BUILDING CODE OF AUSTRALIA COMPLIANCE ASSESSMENT REPORT

S.C.E.C.G.S. REDLANDS, CREMORNE CONCEPT PROPOSAL & STAGE 1 DEVELOPMENT APPLICATION

DATE ► 8.5.2015

REPORT NO. ► PROJECT 5419 - REV 03

INSTALLATION OF 7
ADDITIONAL DEMOUNTABLE
CLASSROOMS AND
RELOCATION OF EXISTING 7
ON TOP OF MUSIC TO
ACCOMMODATE FACULTIES
FROM MOWLL BUILDING (14
DEMOUNTABLES IN TOTAL).

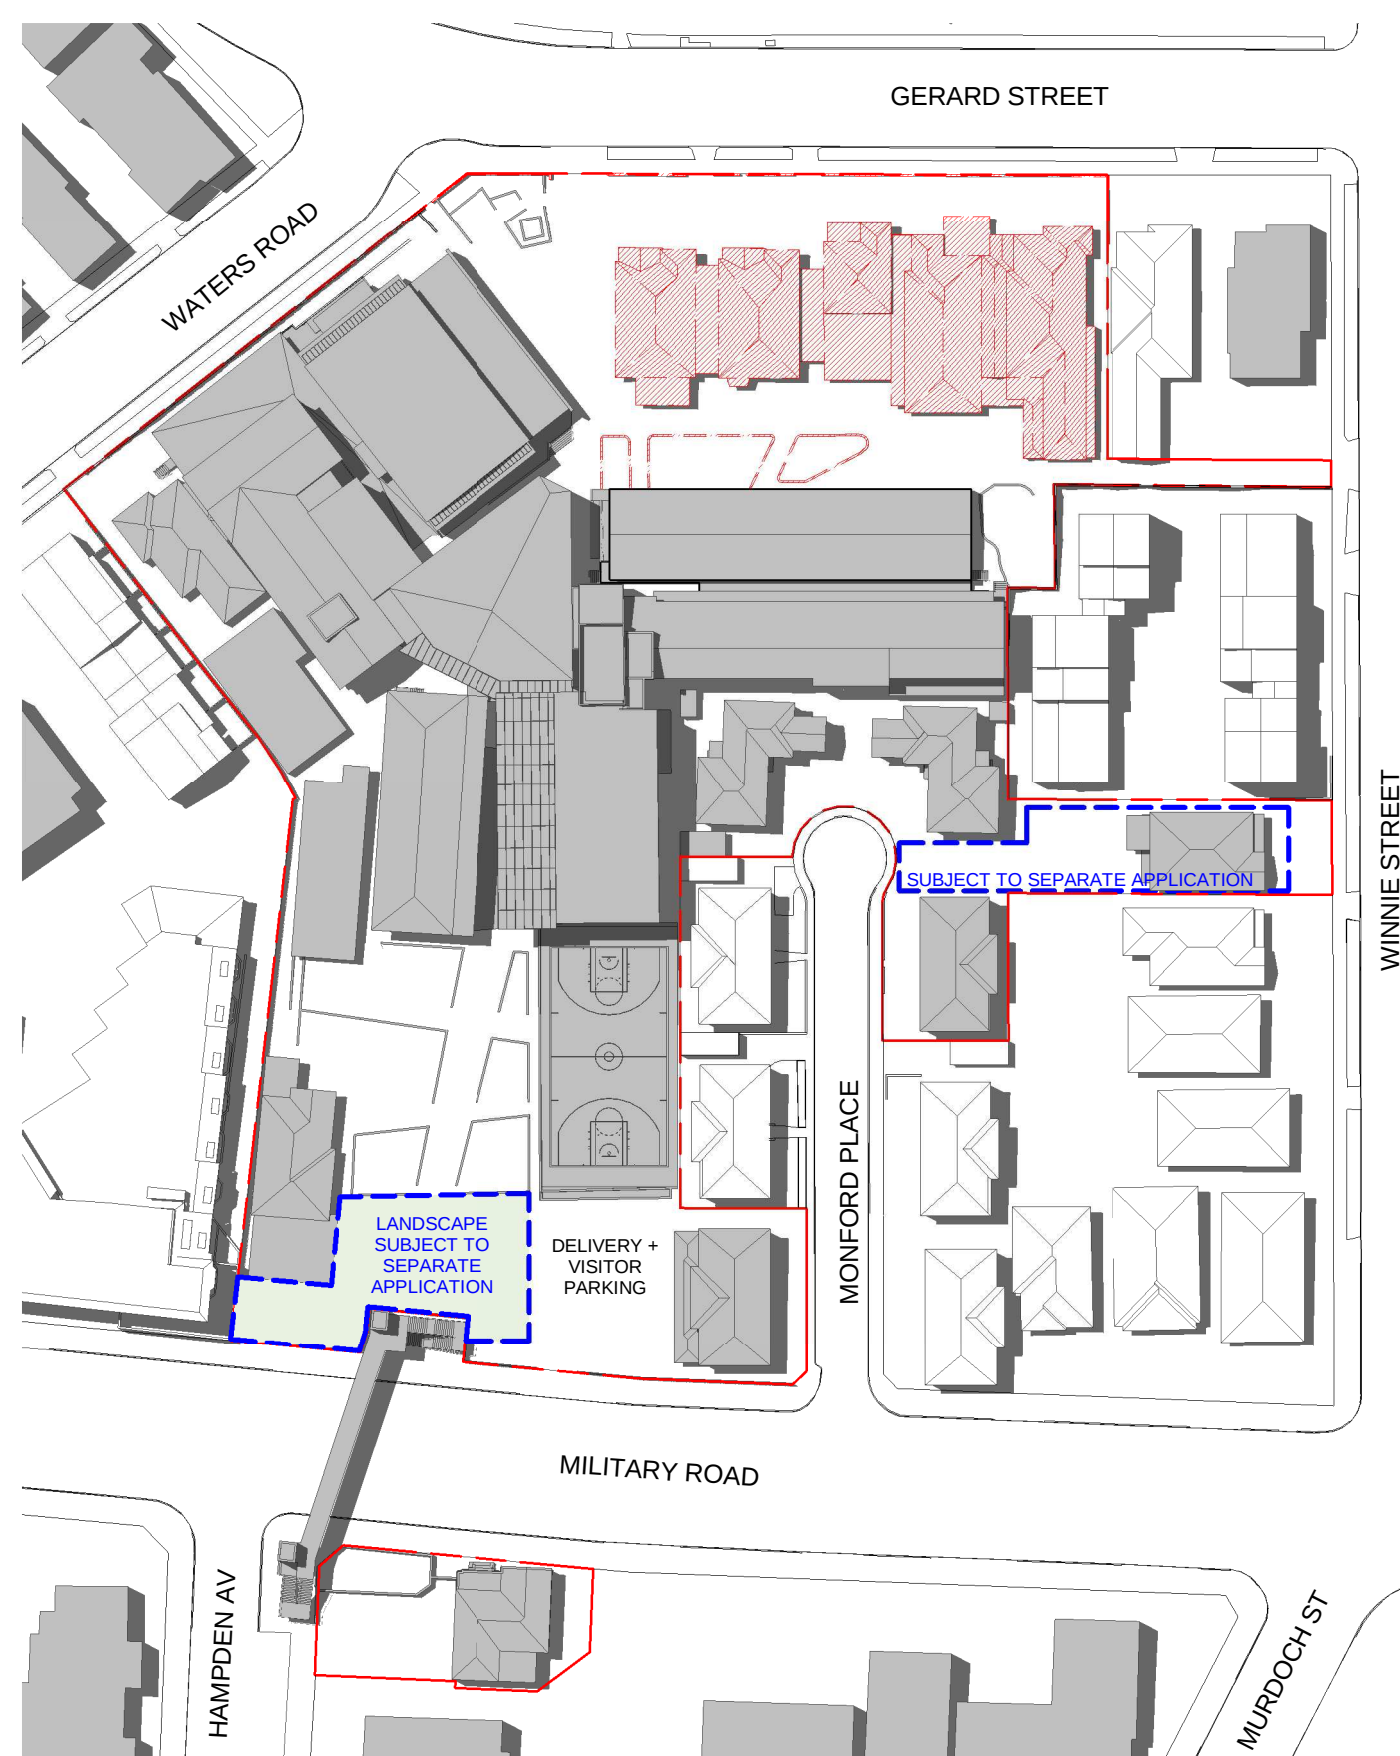
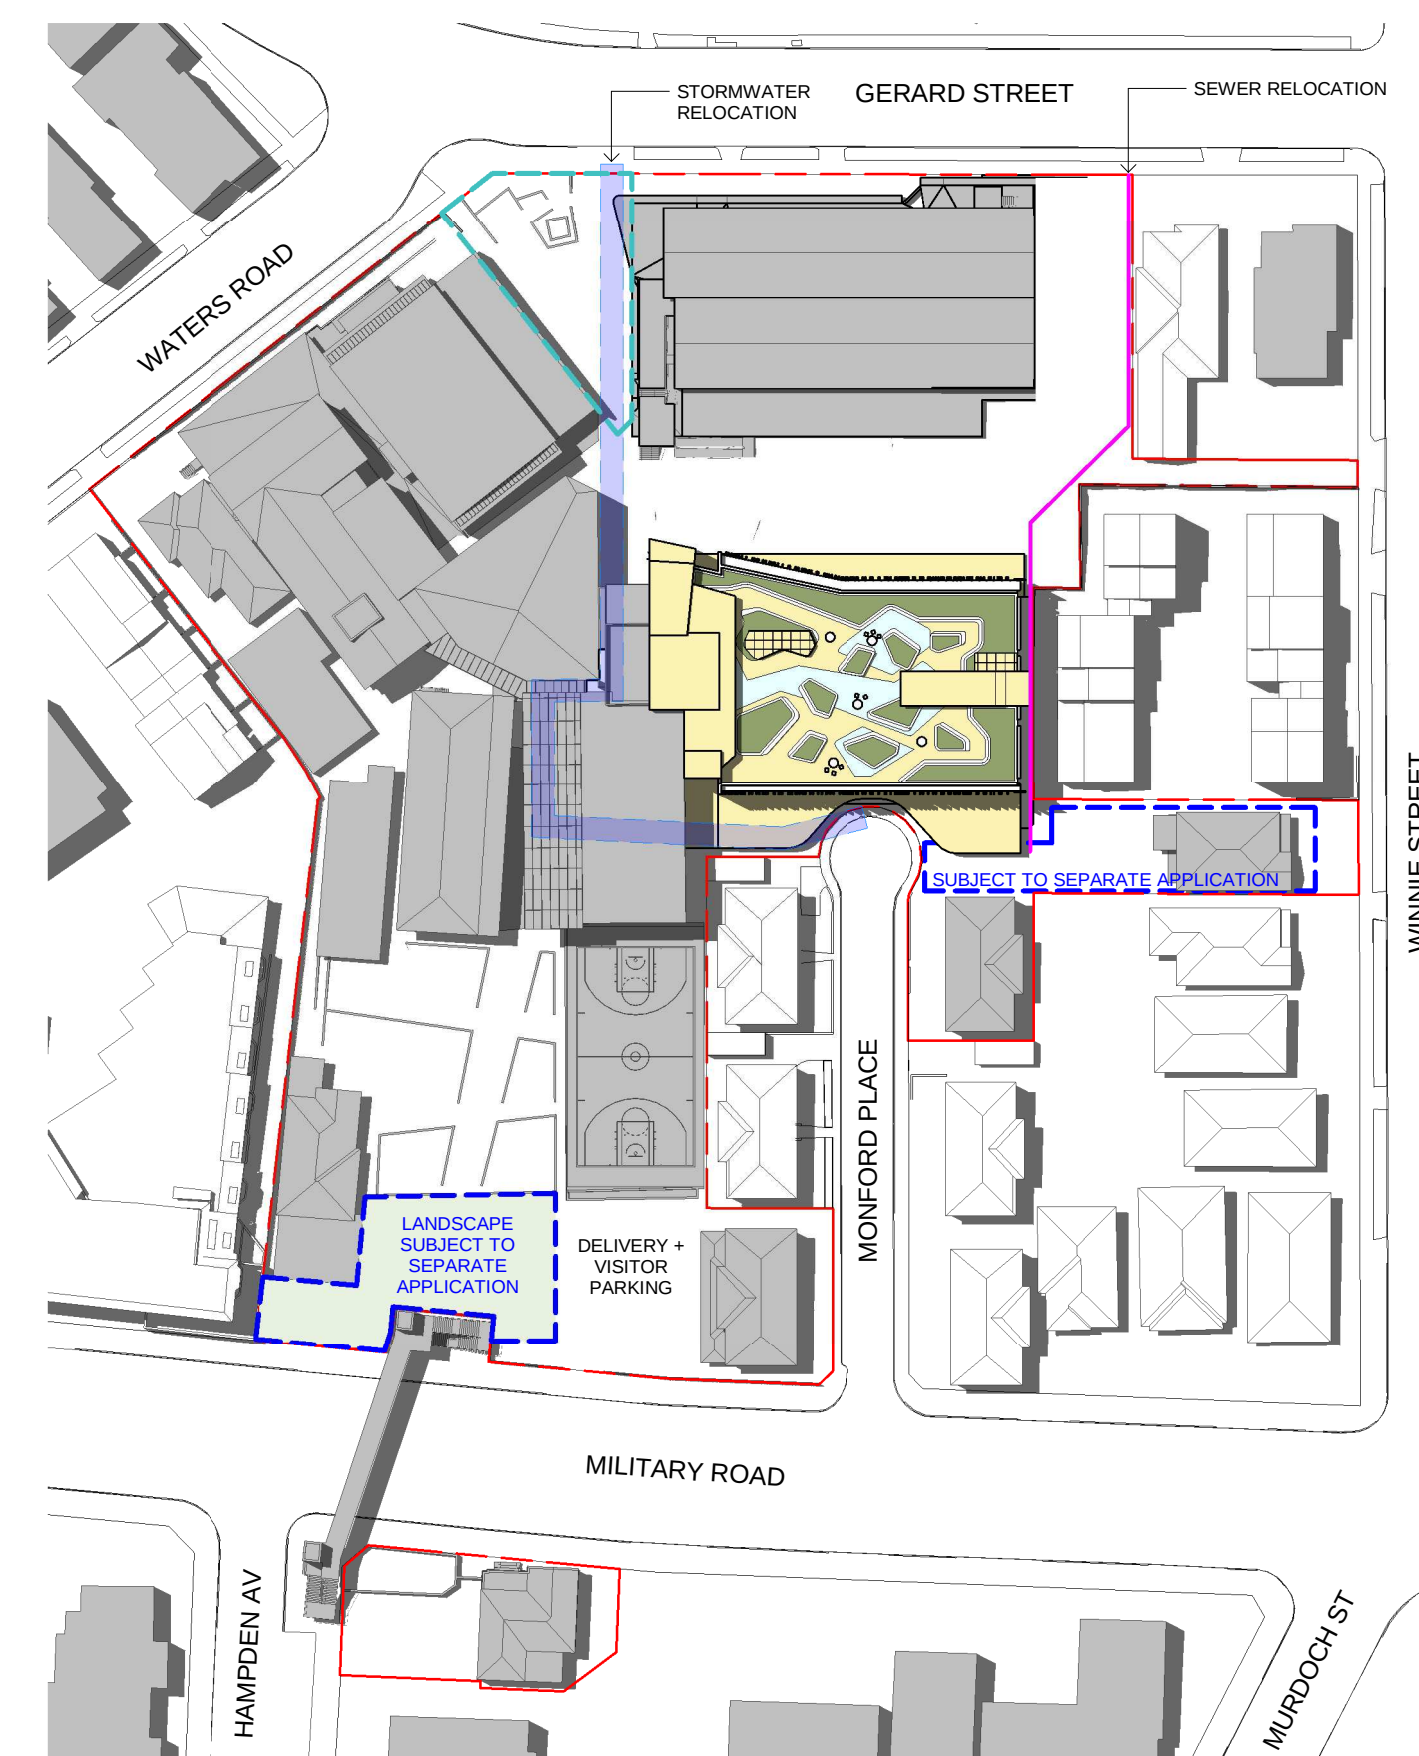
BCA Clause	Deemed-to-Satisfy Provision to be addressed
	<p>only (in lieu of fire rating loadbearing external wall parts);</p> <p>4. Stage 1C – During this stage the roof of the basement music area contains two skylights. Such skylights will be located directly beneath the temporary demountable classroom buildings to be positioned above. Such construction does not satisfy Specification C1.1, as an unprotected opening located within a separating floor.</p> <p><i>Details demonstrating compliance with this clause must be incorporated into the construction certificate plans / specification, or a fire engineered Alternative Building Solution must be attained.</i></p>
<p>C2.2 General Floor Area & Volume Limitations</p>	<p>Fire compartment floor area and volume limitations shall not exceed the following limitations set by Table C2.2:</p> <ul style="list-style-type: none"> ▪ Type A - Class 9b: 8,000 m² / 48,000 m³ ▪ Type B - Class 9b: 5,500 m² / 33,000 m³ <p>Based upon the Master Plan drawings dated March 2015, the largest fire compartment affecting the development occurs on Level 3 (as combines the Learning Hub education building, Roseby building, Humphery building and the Sports and Arts Centre building).</p> <p>This fire compartment approximates 5,200 m² / 15,600 m³, hence not more than the maximum permitted 8,000 m² or 48,000 m³, for Type A construction.</p> <p>Compliance issue –</p> <p>1. Notwithstanding the aforementioned the maximum permitted fire compartment size will be exceeded where Level 3 is linked to other levels via open stair shafts or via the two atrium wells located within the Learning Hub building.</p> <p>Hence fire wall construction must be introduced to reduce the size of fire compartments to comply with Table C2.2, <u>OR</u> fire engineered alternative solutions will be required relevant to the ability of the open stair shafts / atrium wells to provide adequate fire separation between storeys.</p>
